Executive Summary – State Significant Development Application - Block 1 (SSD 6554)

This is the executive summary to accompany the PPR documentation prepared in response to the letters received from the Department of Planning and the Environment dated 27th November 2014 and the City of Sydney dated 31st October 2014. The letters relate to the State Significant Development Application for a Mixed-use Building , Block 1 (SSD 6554) at Central Park, Chippendale. This executive summary primarily relates to the architectural items raised within these letters. For any other non-architectural items, please refer to the wider submitted PPR documentation for the dedicated reports and studies by the wider Design Team for the project. In the first instance, please refer to the covering summary letter provided by JBA for direction.

Layout as proposed in SSDA for Block 1

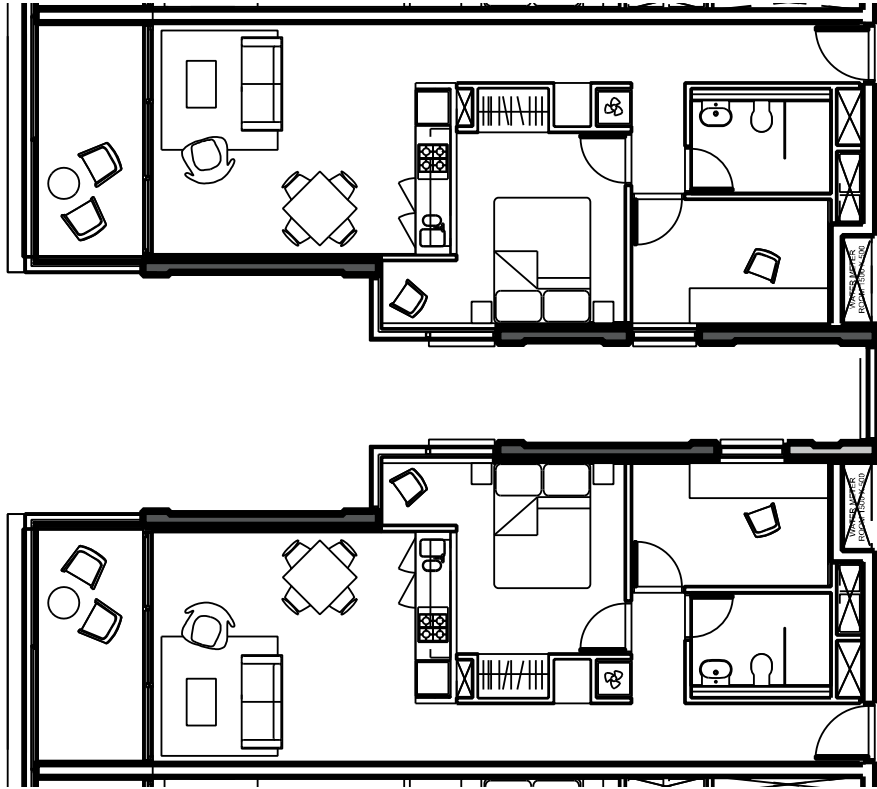
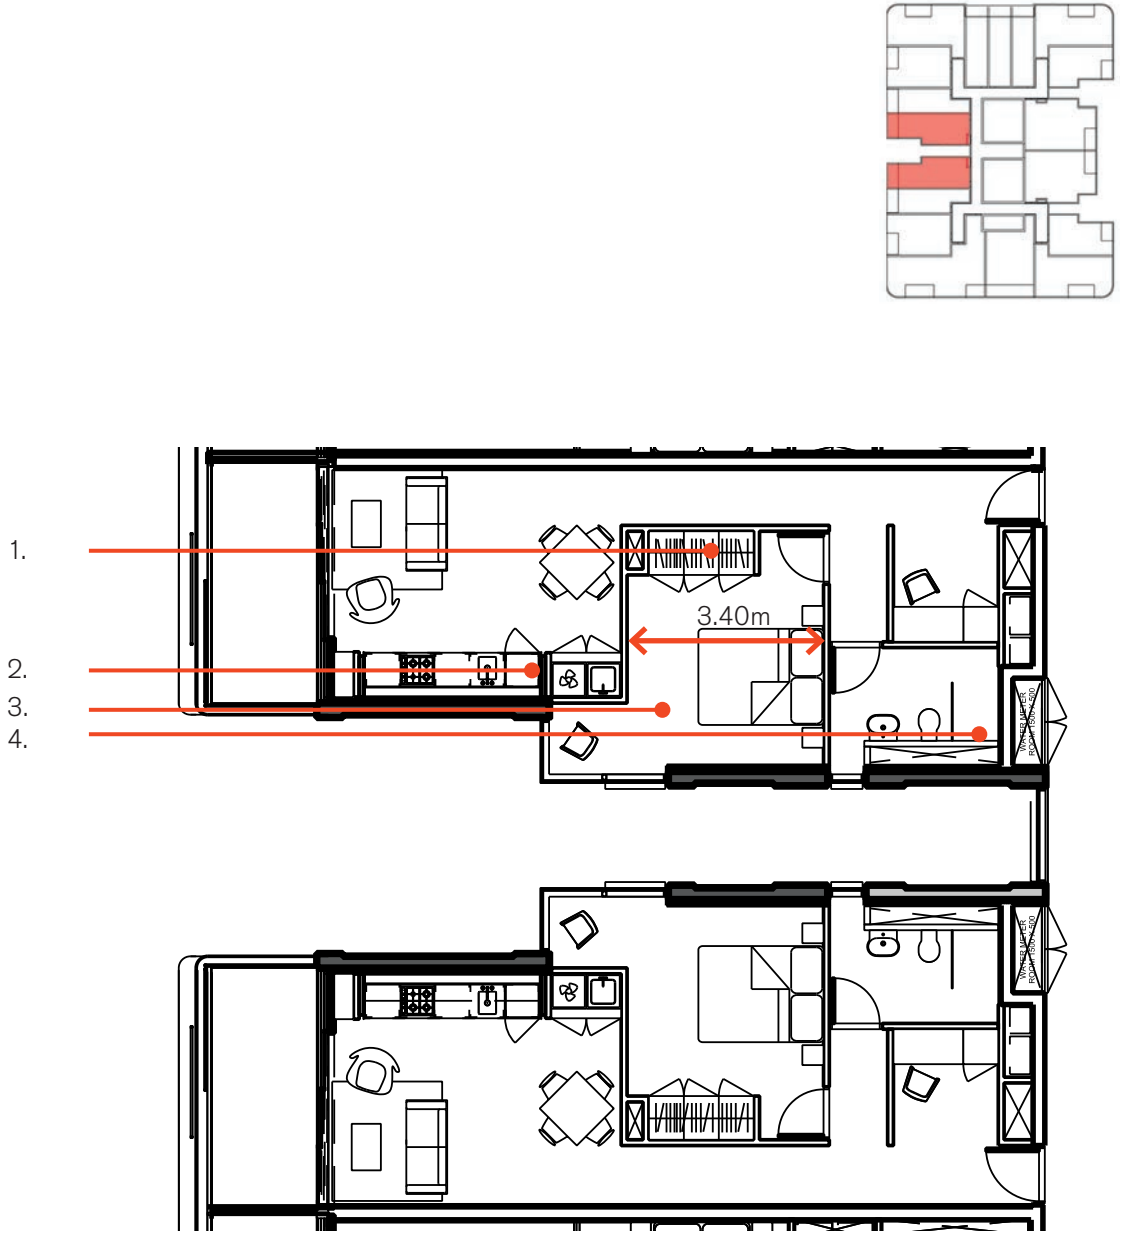
Amenity of Bedroom/Studies

The layout of the respective apartment typologies affected by this point have been subsequently revised to reconfigure the apartment layouts. This has led to the following amendments being made based on the respective apartment locations. Clearer diagrams explaining the changes are included within the actual PPR report allowing the apartment layouts to be reviewed together:-

Layout as proposed in SSDA for Block 1

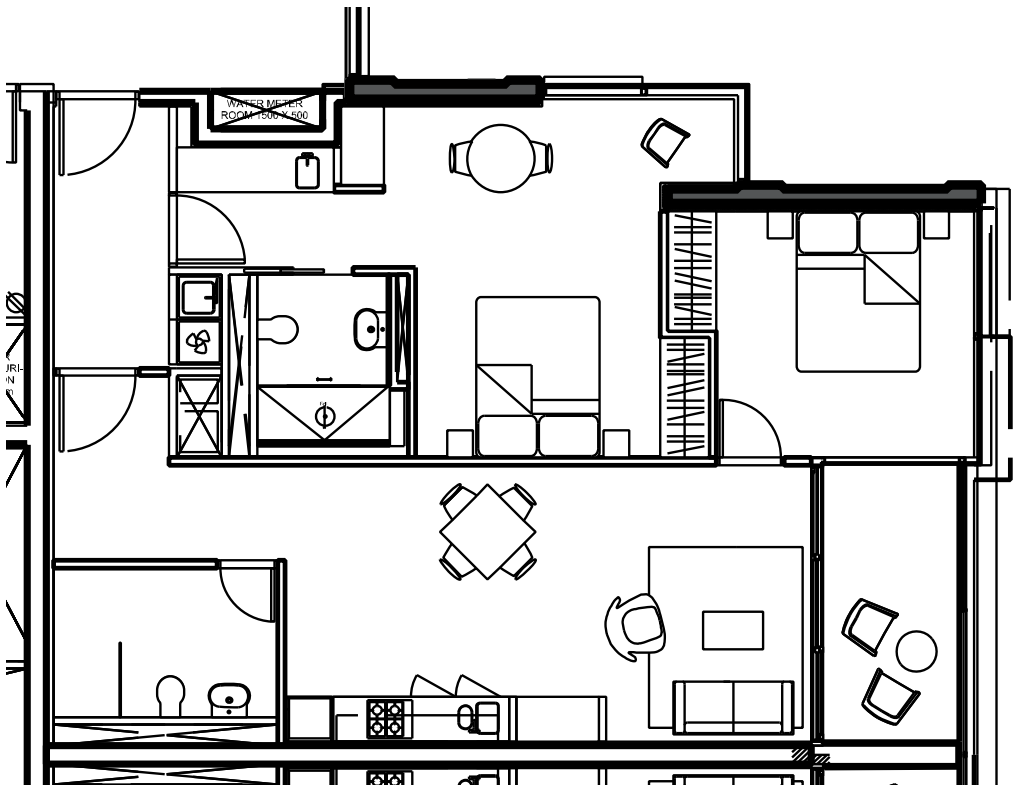
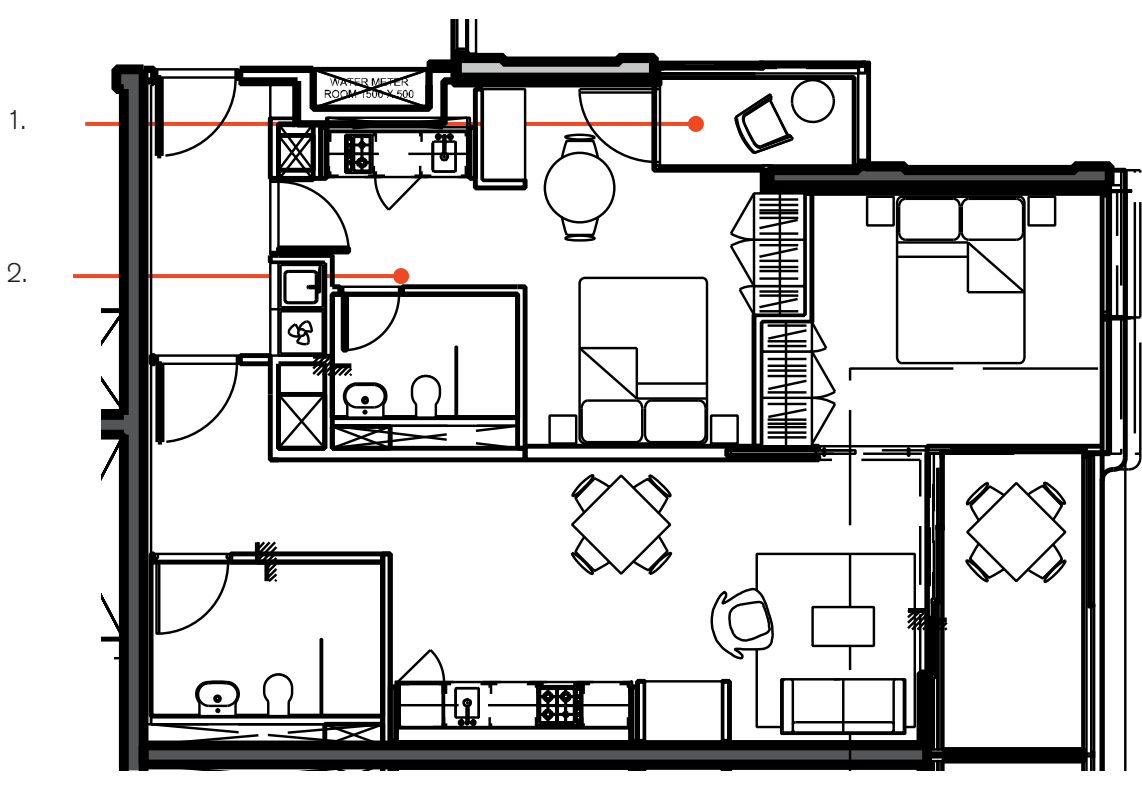
Amenity of Dual Key Apartments

In response to this point, the layouts were revised within the respective 2-bed and 3-bed units to ensure a balcony (or loggia in some instances) was introduced for the second key apartments to provide a private open space when occupied separately. This is further explained in A-SK-0921 DoP&E Response Report, Section 3.11 where the revisions to the layouts are highlighted clearly. It should be noted that additional communal amenity space is provided at Level 02 as part of the swimming pool, jacuzzi, gym and media area as well as Level 16 on the shared communal terrace where barbeque facilities and external landscaping space is provided.

Title
BLOCK 1+4N
BASEMENT 03

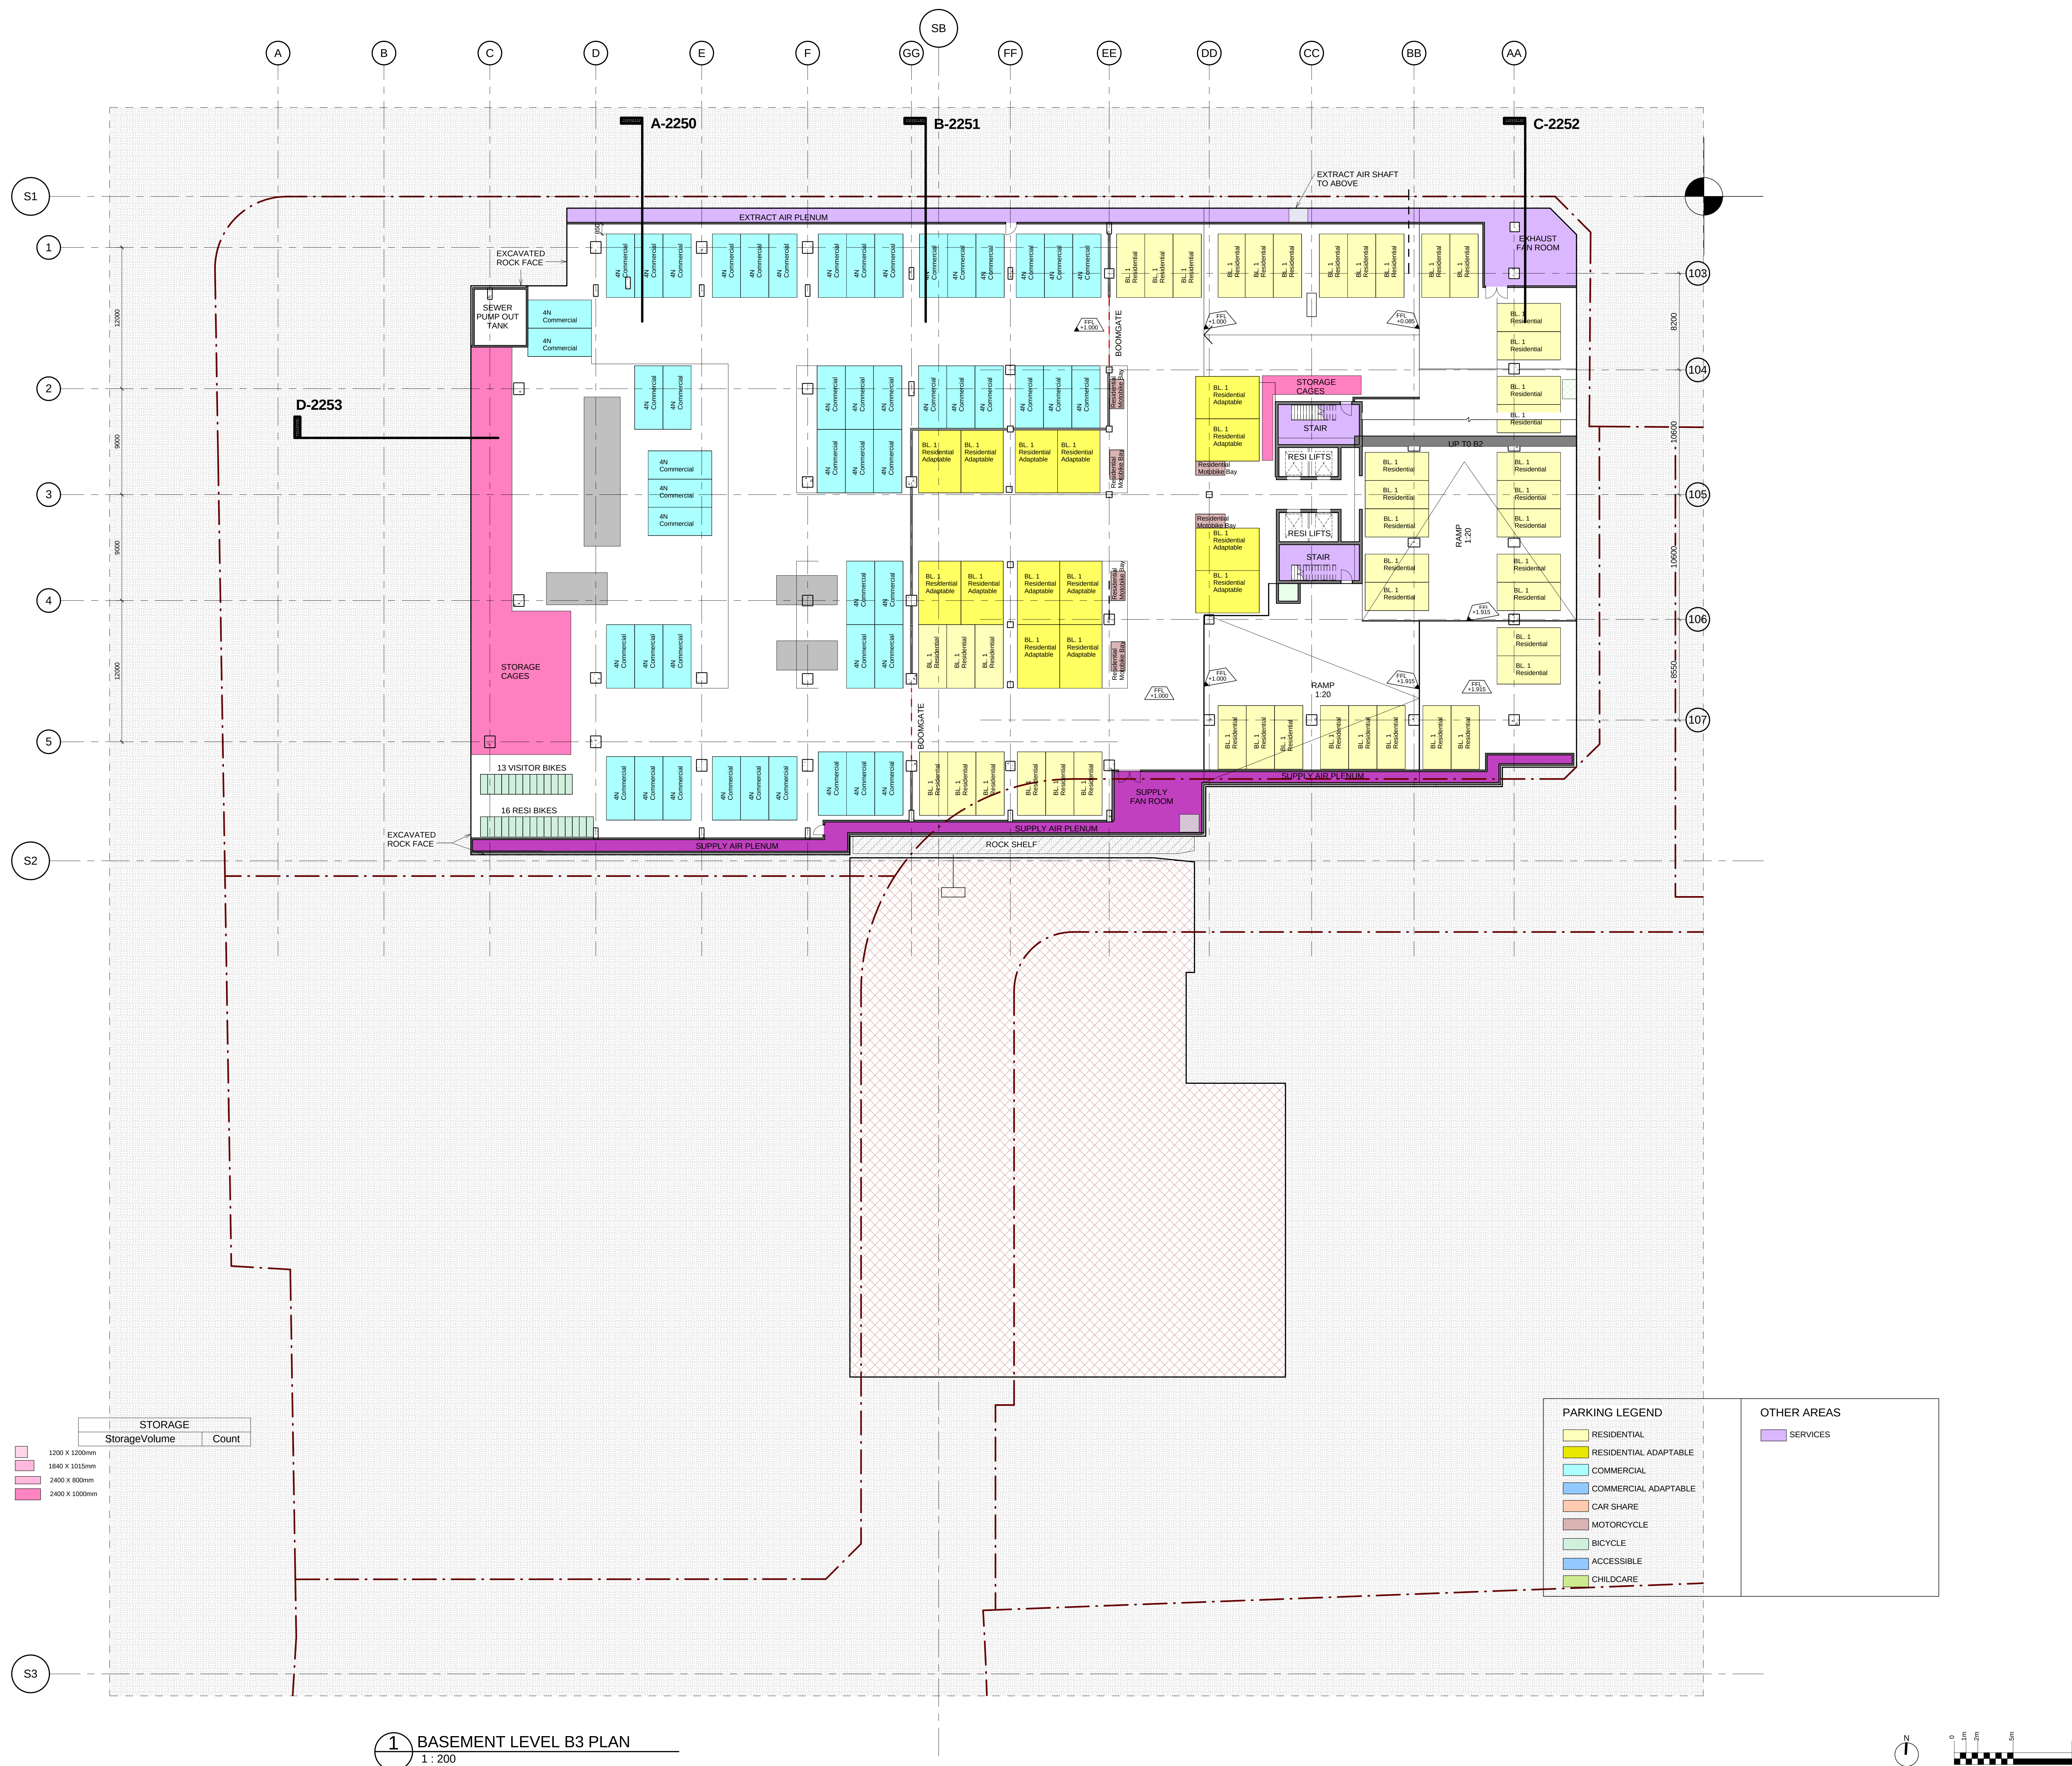
Amended basement plans that incorporate the “construction” of the basement into only one of the applications (either to be built in conjunction with Block 4N or in conjunction with Block 1) and should be deleted (or shown as indicative only) on the other application.

All bicycle parking spaces and storage areas should be shown on the relevant set of basement plans.

The PPR documentation has been revised to now illustrate each apartment typology within the building. This is reflected in the PPR drawings PA-A1-1755 to PA-A1-1759 inclusive. This is also reflected within the GA sections within the PPR documentation. The relevant information within the Block 4N PPR documentation have been revised to cross-reference with the Block 1 PPR documentation.

The PPR documentation has been revised to now indicate the bicycle parking and storage areas within the basement of the building. This is reflected in the PPR drawings PA-A1-1755 to PA-A1-1759 inclusive. The spreadsheet indicated on PA-A1-1020 should also be referred to.
